The Coal
Authority

Re: Planning application 2025/0830

Erection of sub-station at 428 Carlton Road, Carlton, Barnsley, S71 3HX

The Coal Authority response: FUNDAMENTAL CONCERN

Drawing No: **R0542 - 400** PO

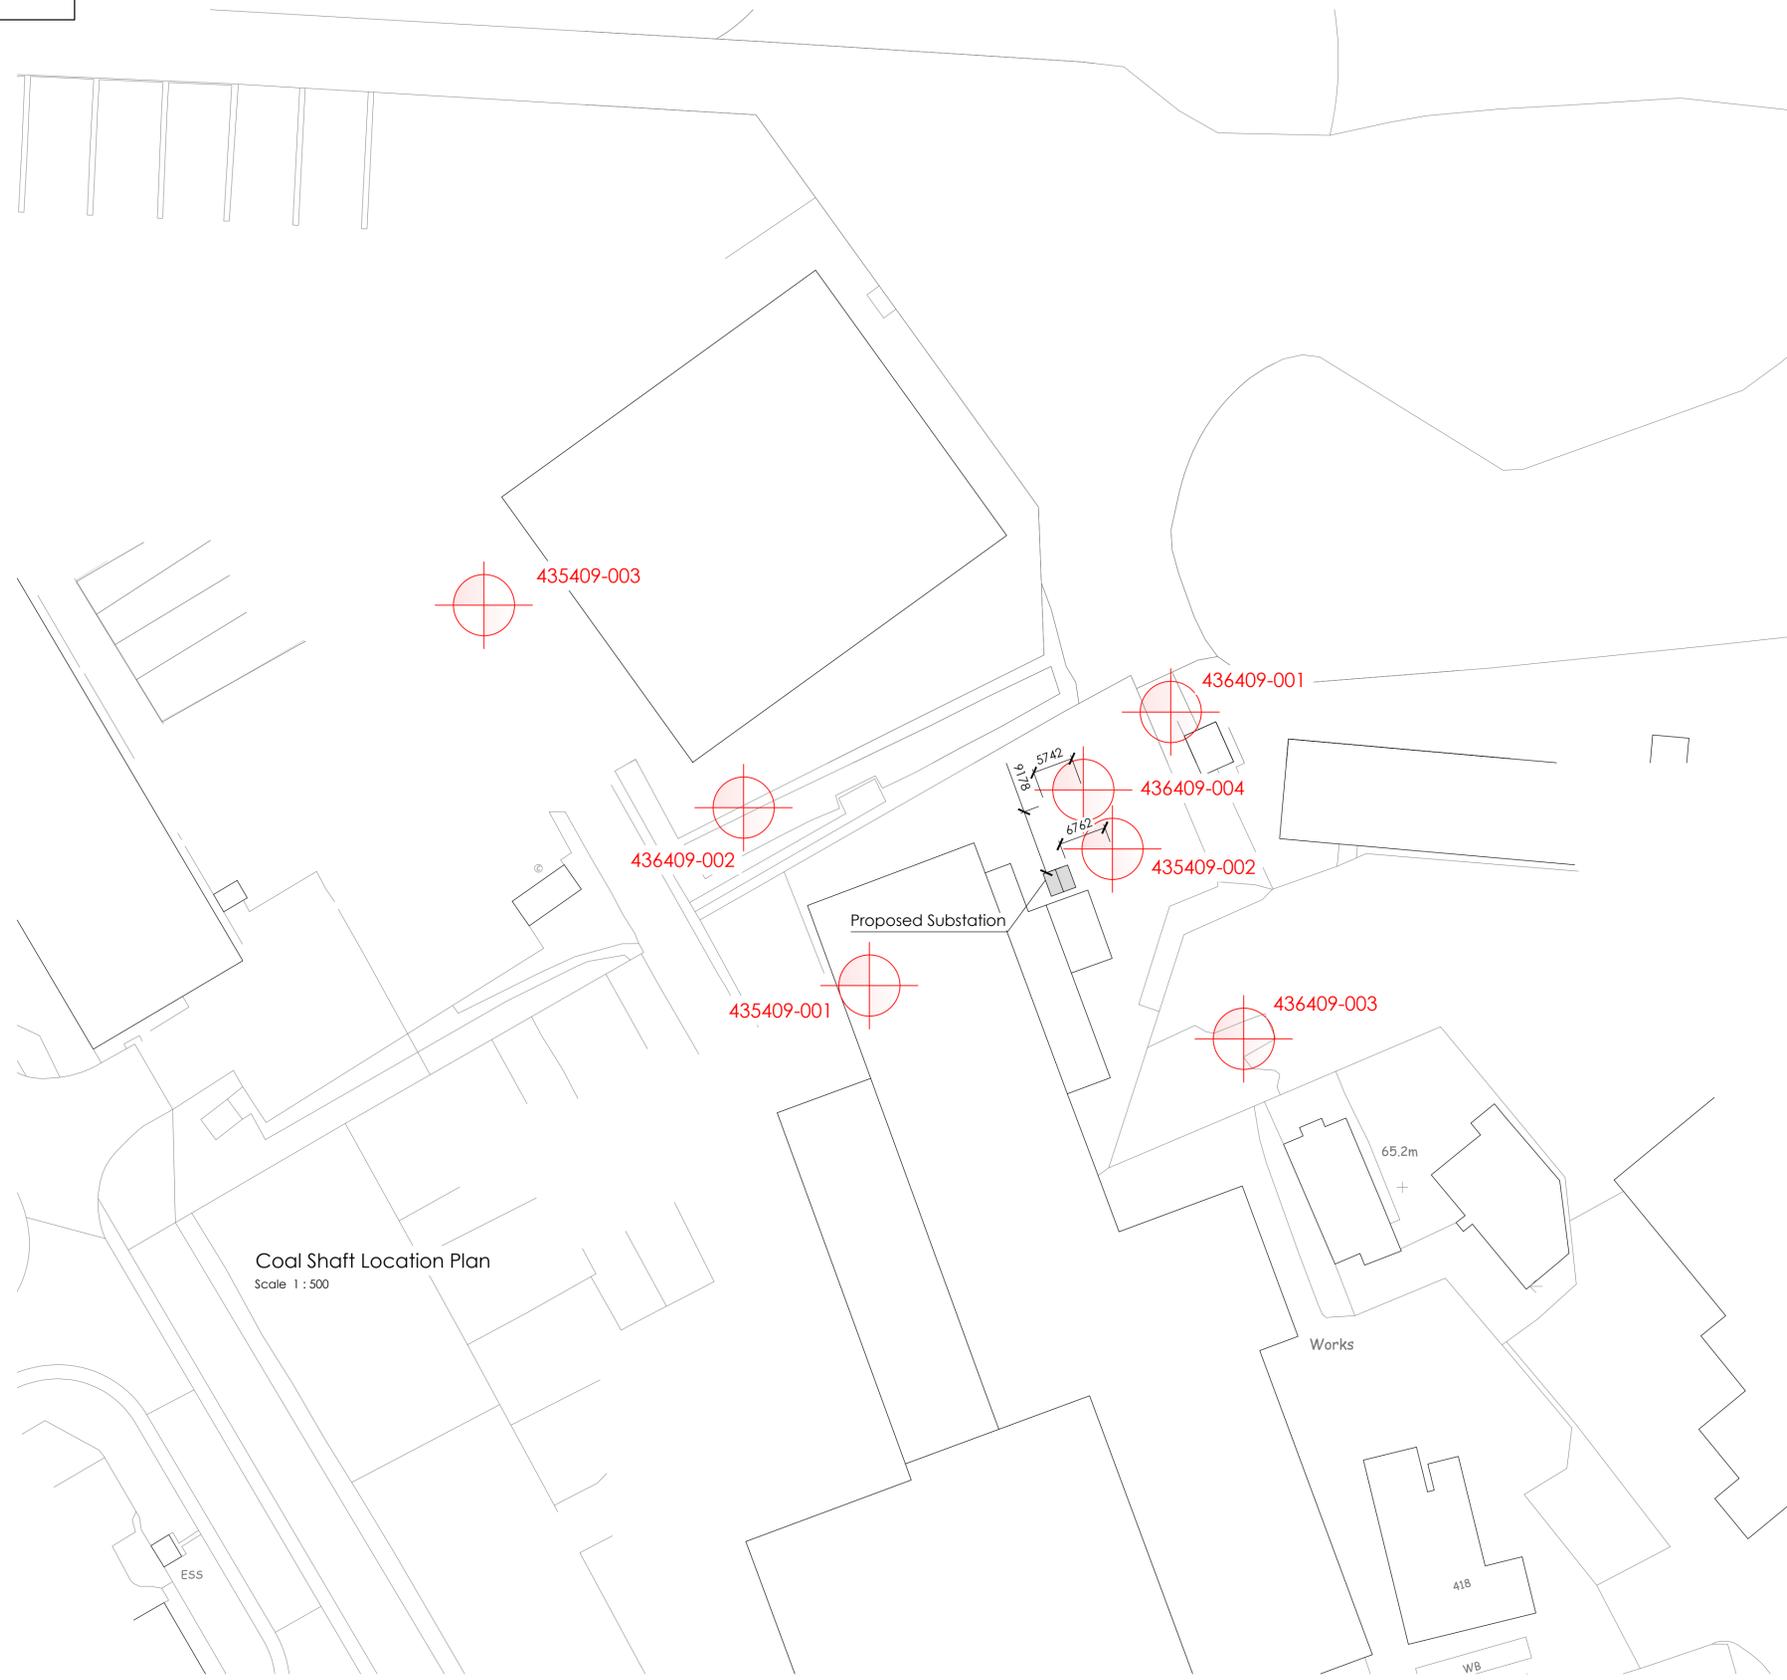
In this case, it is evident that the proposed building will be sited within the potential zones of influence of mine shafts 436409-001 and 436409-002 and, due to potential plotting inaccuracies, could actually be located over shaft 436409-002. We hold no treatment details of for either of these shafts, which are recorded to be 43m deep. This would conflict with our adopted policy.

In order to demonstrate that the proposed building has been suitably informed by the presence of the mine shafts, we consider that investigations designed and carried out by competent persons should be undertaken prior to determination of the planning application. These investigations should seek the location of the mine shafts and to establish the extent of their associated zone of influence.

The results of these investigations should be incorporated into the required Coal Mining Risk Assessment, and should be used to demonstrate to the LPA that the risks posed by the mine shafts are fully understood and to demonstrate how these risks are to be suitably addressed. They should also be used to inform any necessary revisions to the proposed building to demonstrate that it avoids the zone of influence of the shafts.

Given our adopted policy, we consider the LPA should explore the possibility with the applicant of alternative positions for the substation clear of the mine shafts and their associated zones of influence.
